Green Hill Solar Farm

Statement of Common Ground: North Northamptonshire Council Revision **AB** (Tracked)

Document Reference: ~~EX4~~EX5/GH8.3.1_AB

Title:
Figure 13.3 (Rev A): HGV Routes to Scheme
(North Area)

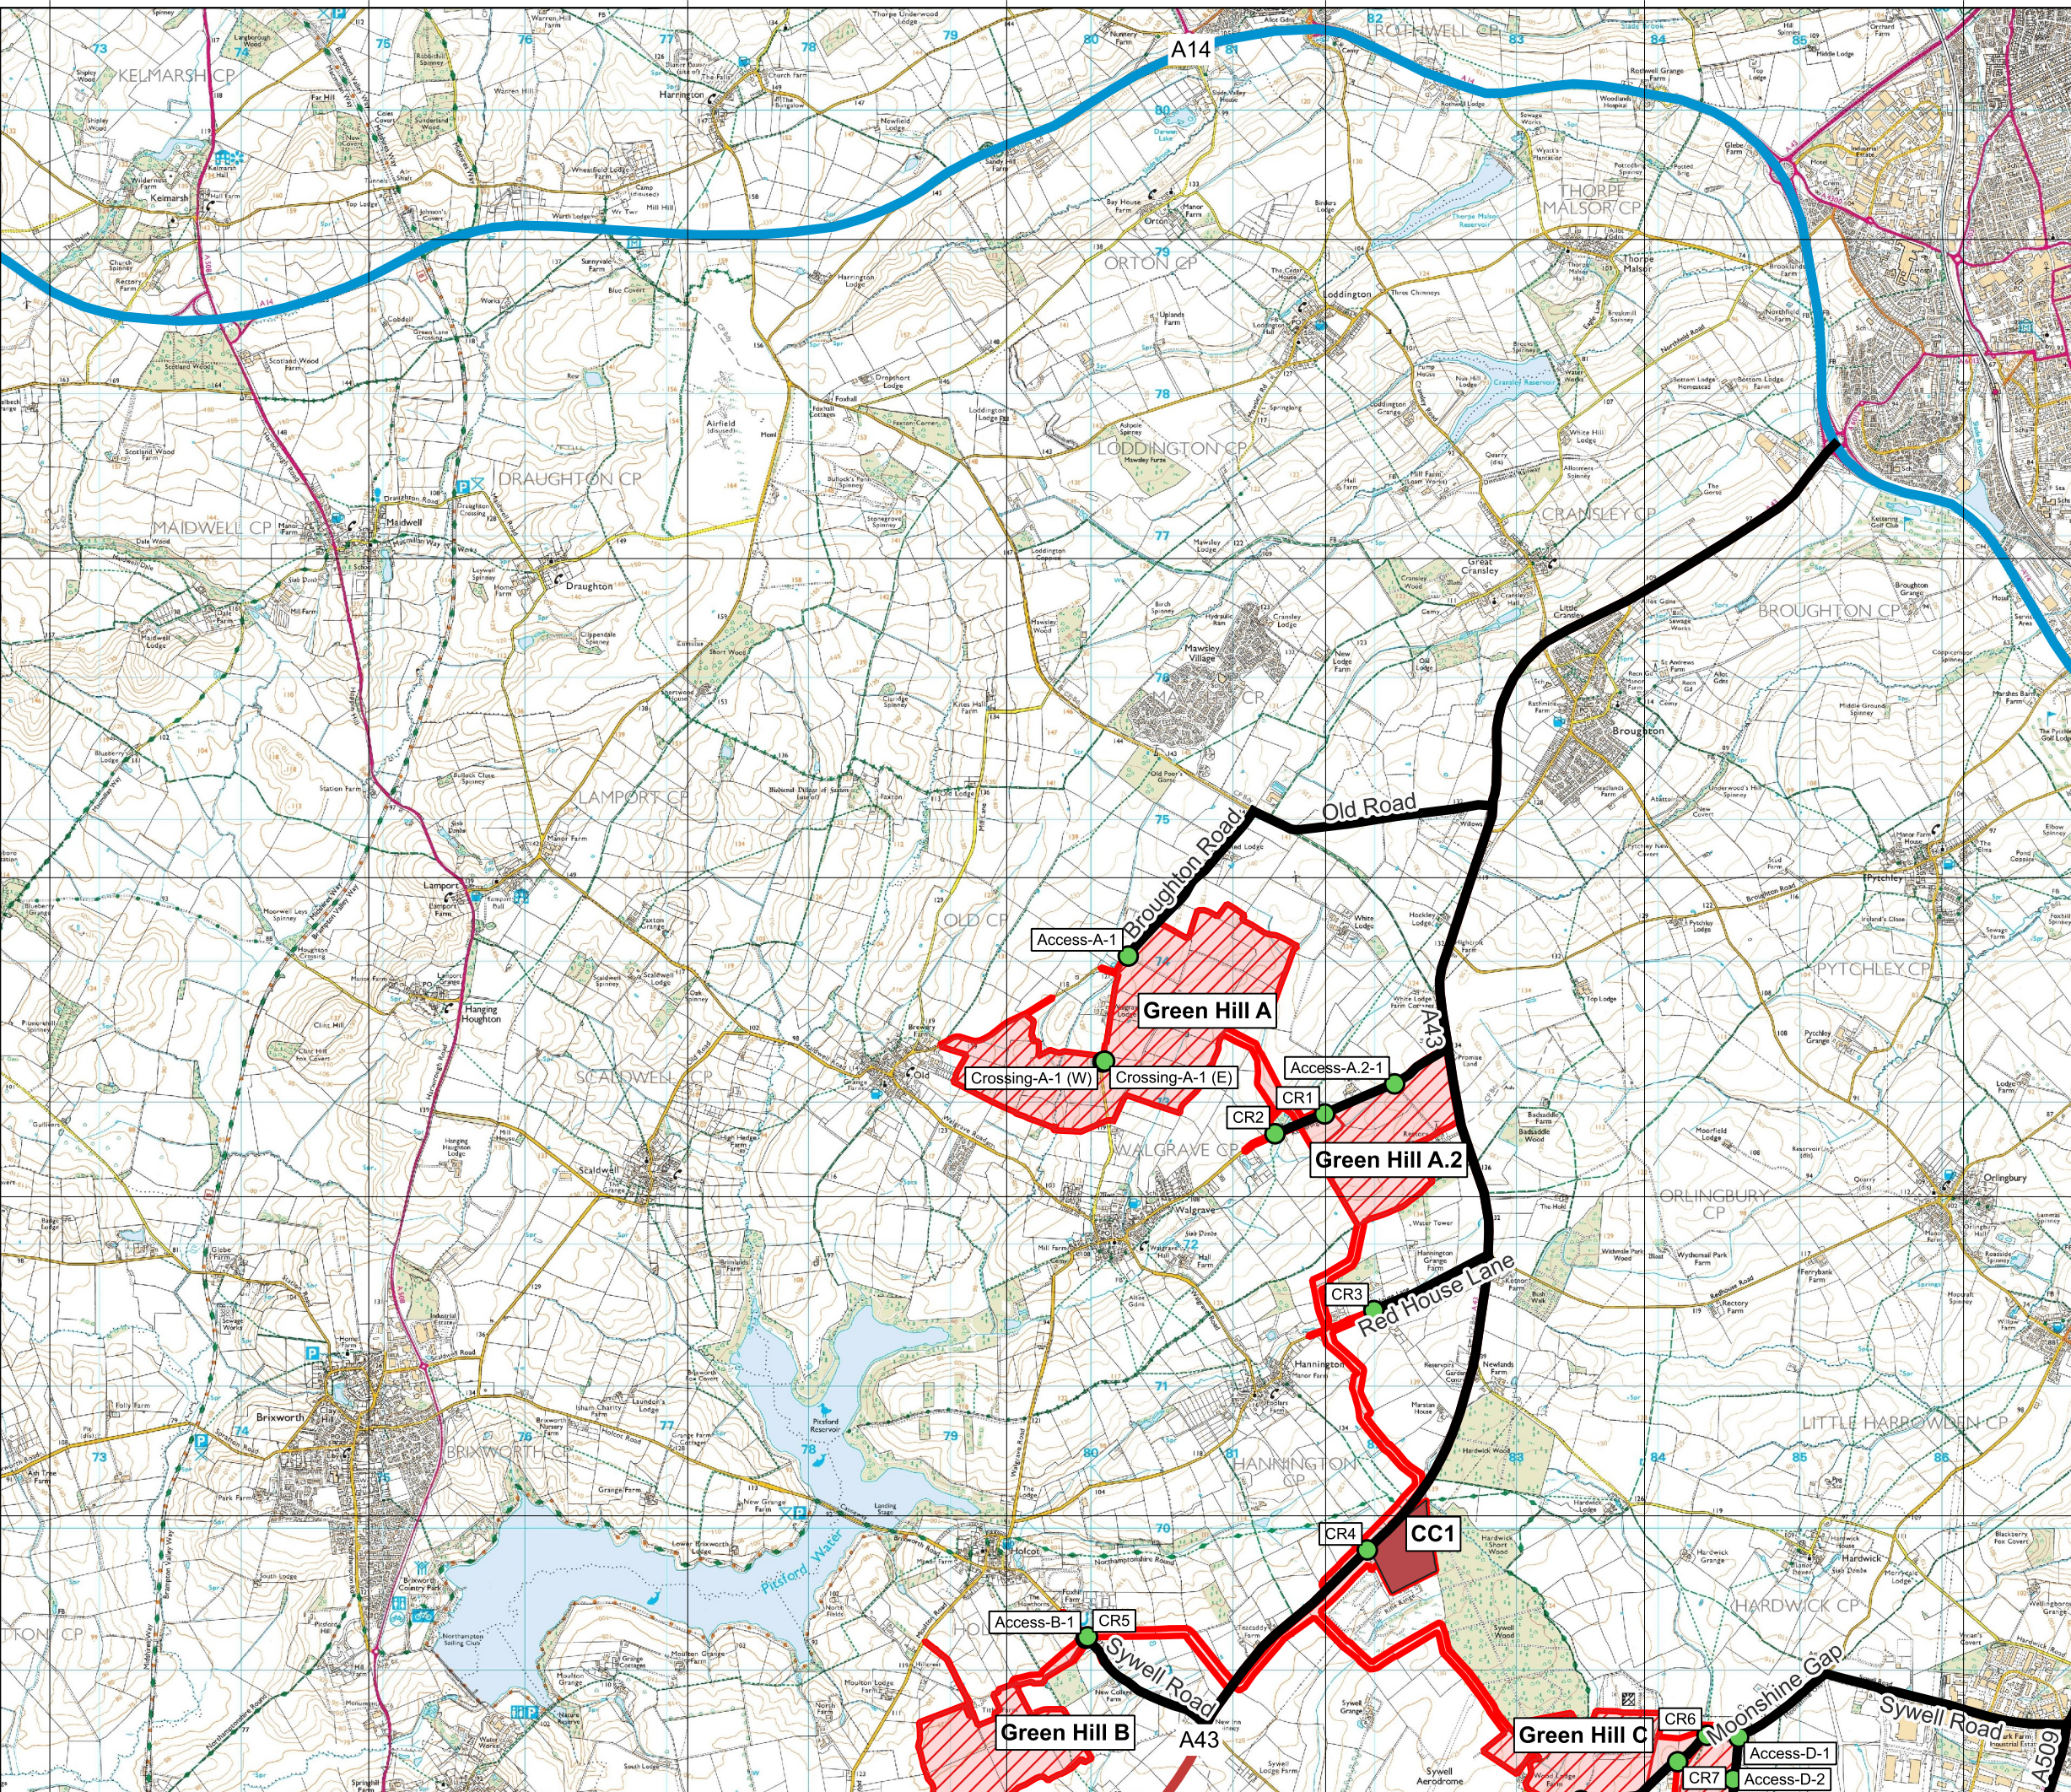
TA-05	HGV Routes	ES Chapter 13: Transport and Access [REP2-003]	All HGVs associated with the construction phase of the Scheme will follow the designated routes as illustrated in figures 13.13 to 13.17 and are summarised in ES Chapter 13: Transport and Access Table 13.10, and these routes are considered appropriate and acceptable.	The Council is in agreement on this matter.	Matter Agreed.
TA-06	PRoW	ES Chapter 13: Transport and Access [REP2-003]	The measures to manage potential impacts identified in the Outline Public Rights of Way and Permissive Paths Management	The Council is in agreement on this matter.	Matter Agreed.
